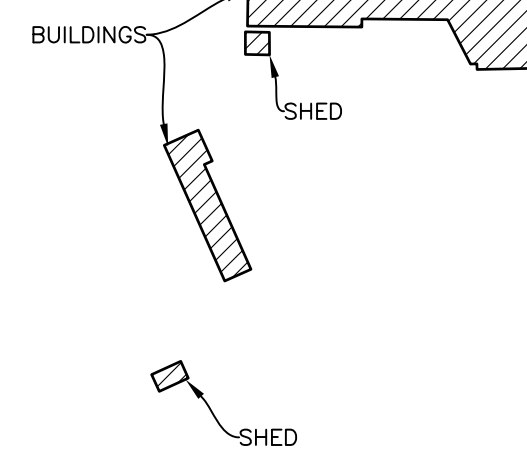
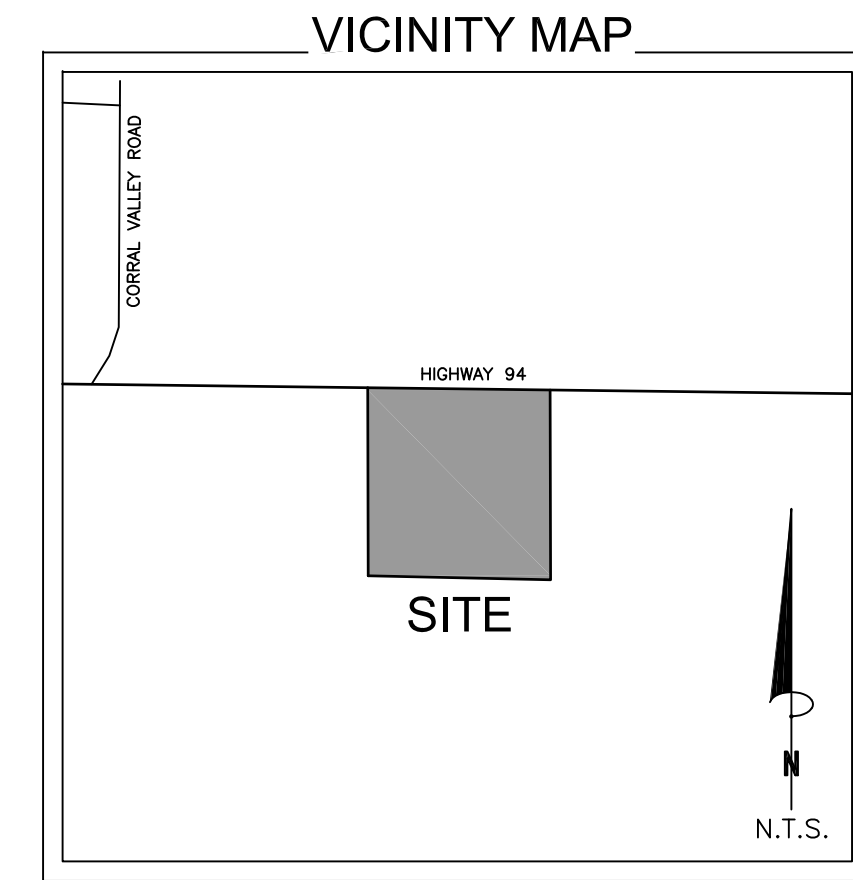
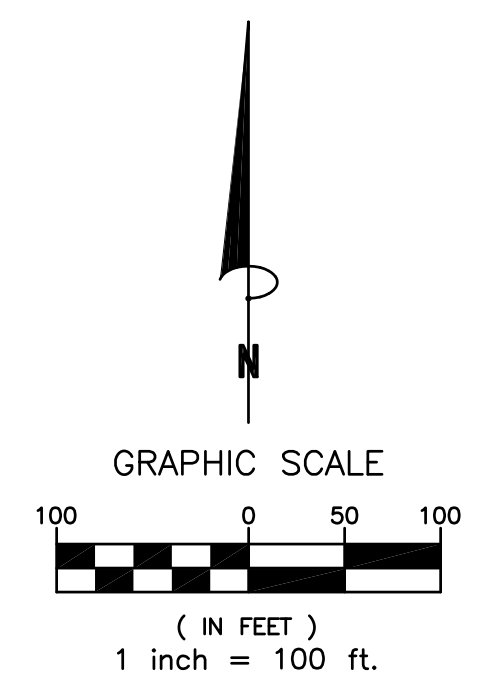
include the mineral holders on the rezone map
